Application for a Non-Material Amendment Following a Grant of Planning Permission

Proposed dwelling and detached garage

H12-0930-24

For the removal or re-wording of condition 5 on the decision notice to remove reference to 'BNG enhancement land'. The land to rear of plot will now remain as existing grass paddock - beyond the domestic curtilage.
To also amend condition 2 to refer to updated site plan with reference to 'BNG enhancement land' removed.

Proposed Site Plan 1:500

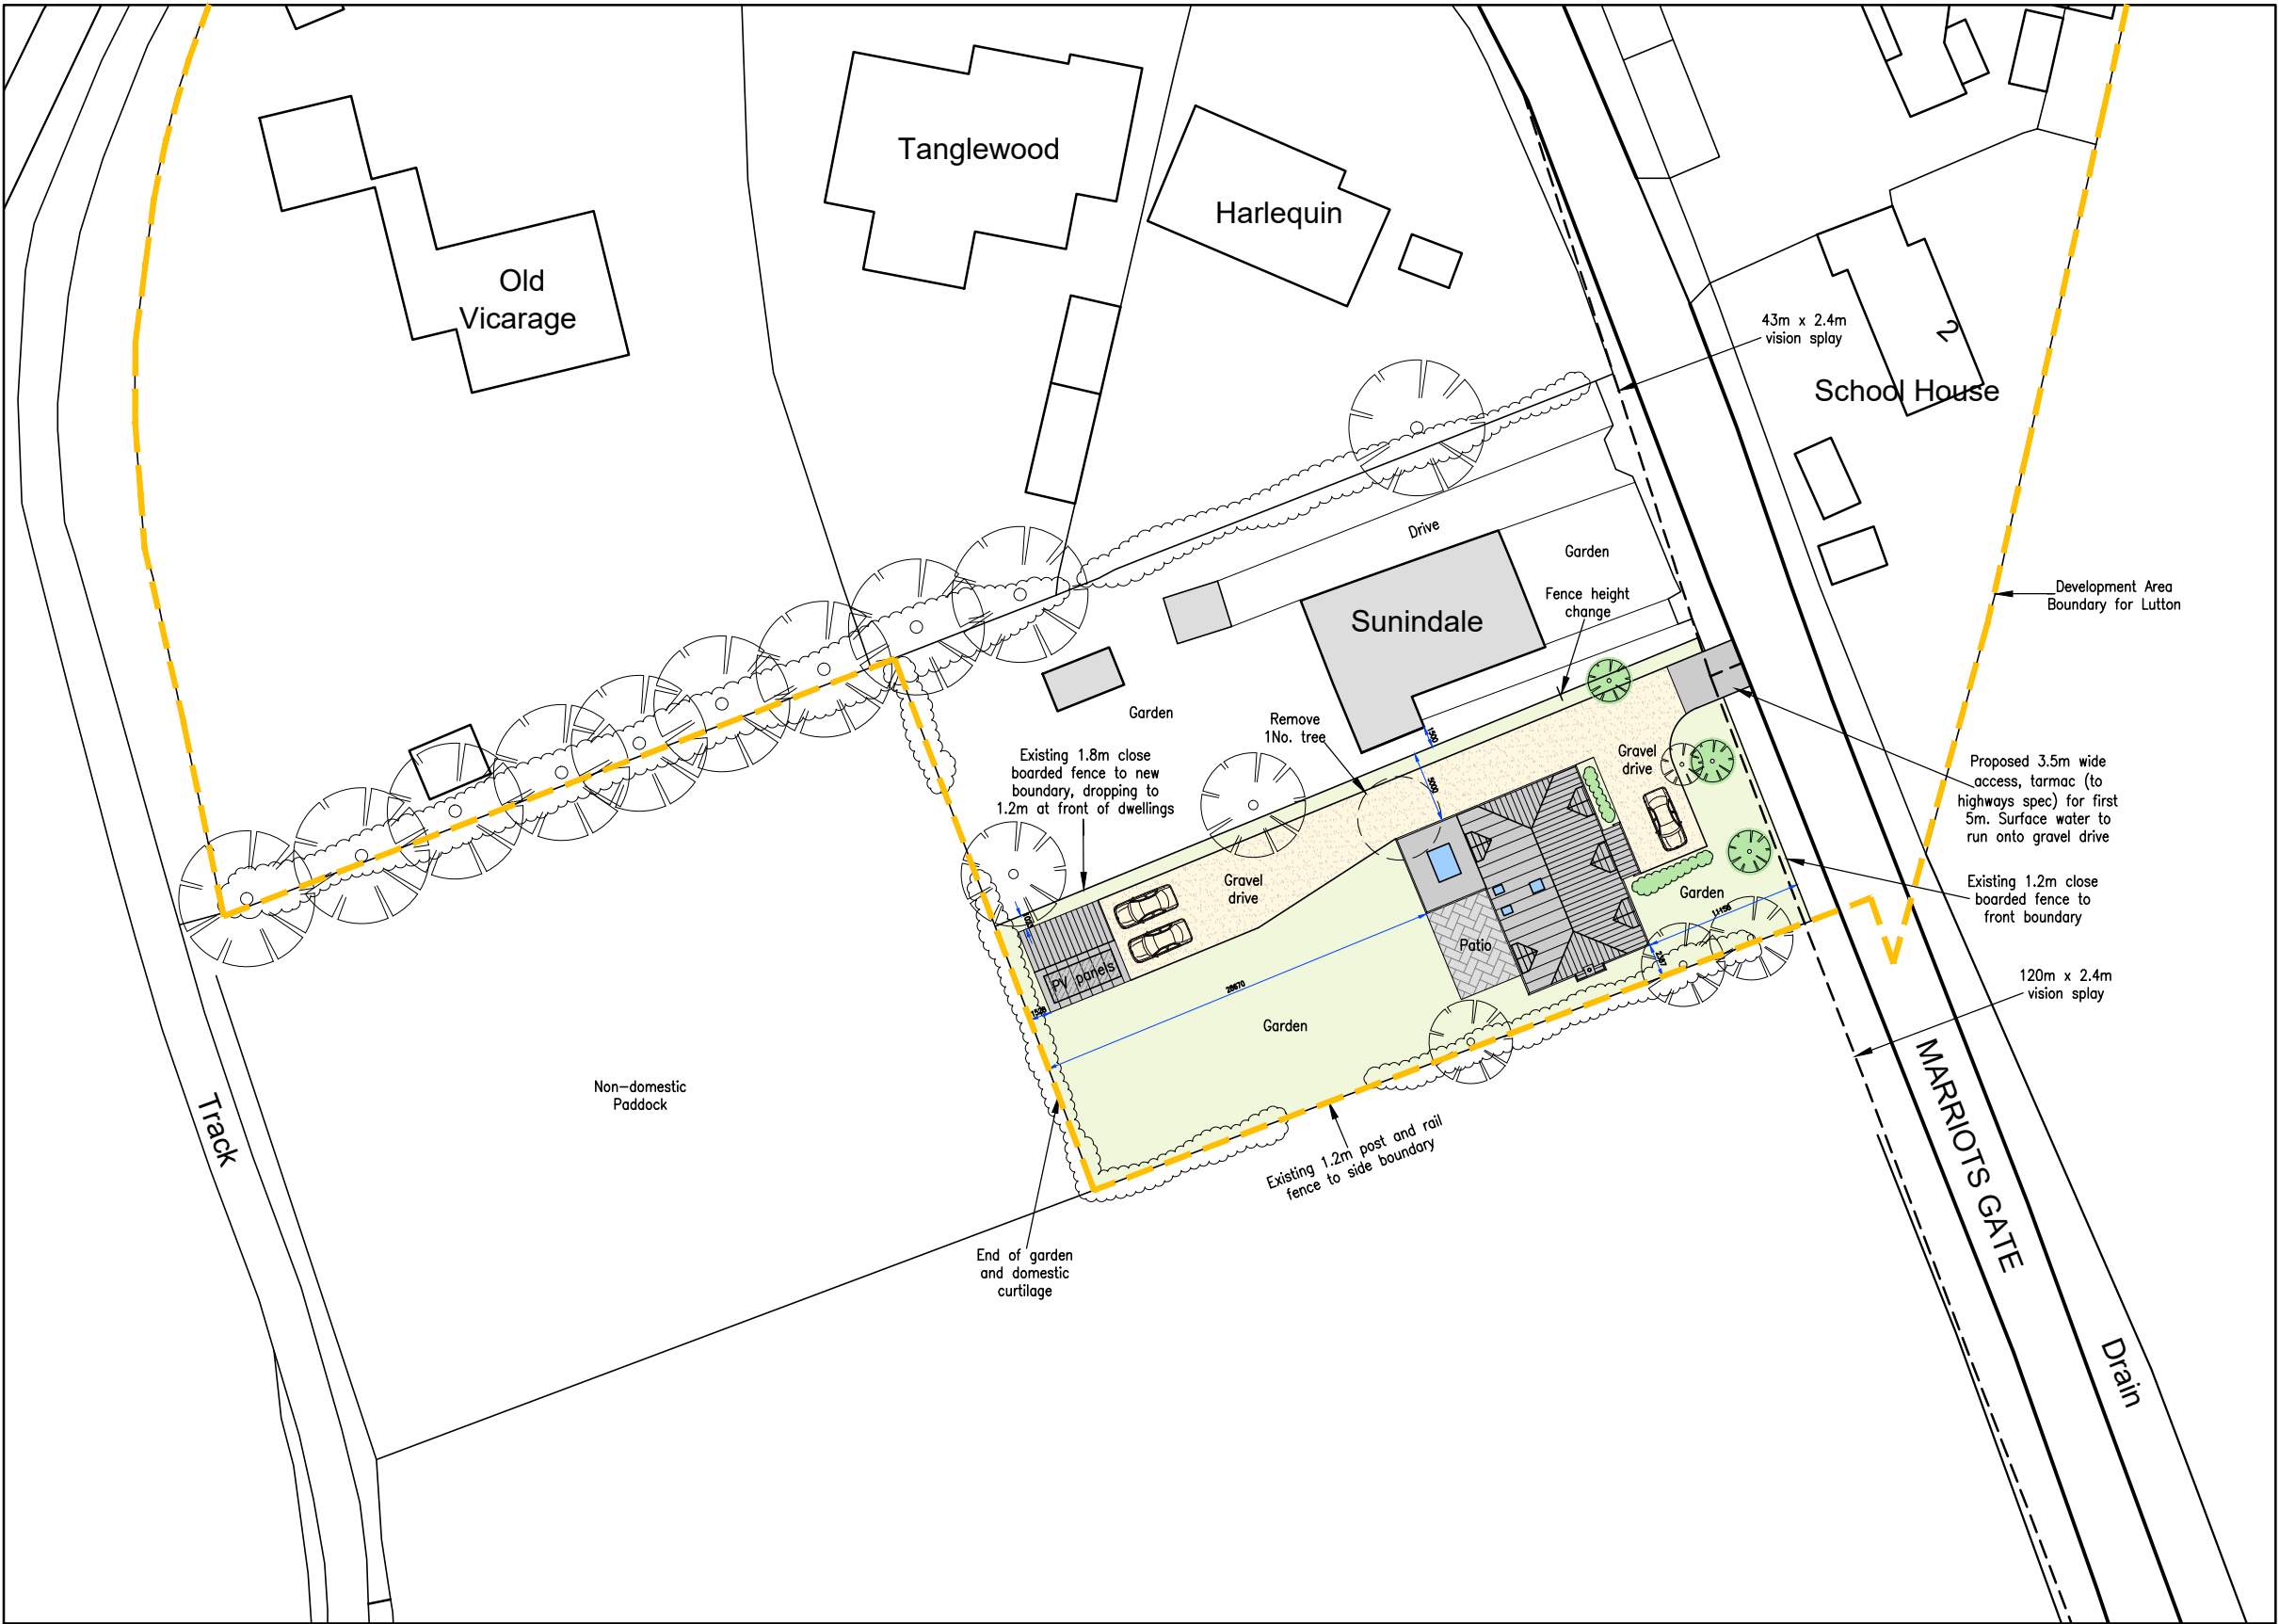
Instead of delivering the BNG compensation on site (as originally proposed), payment has now been made for off-site BNG compensation, as per the evidence submitted and discharged via the planning condition.
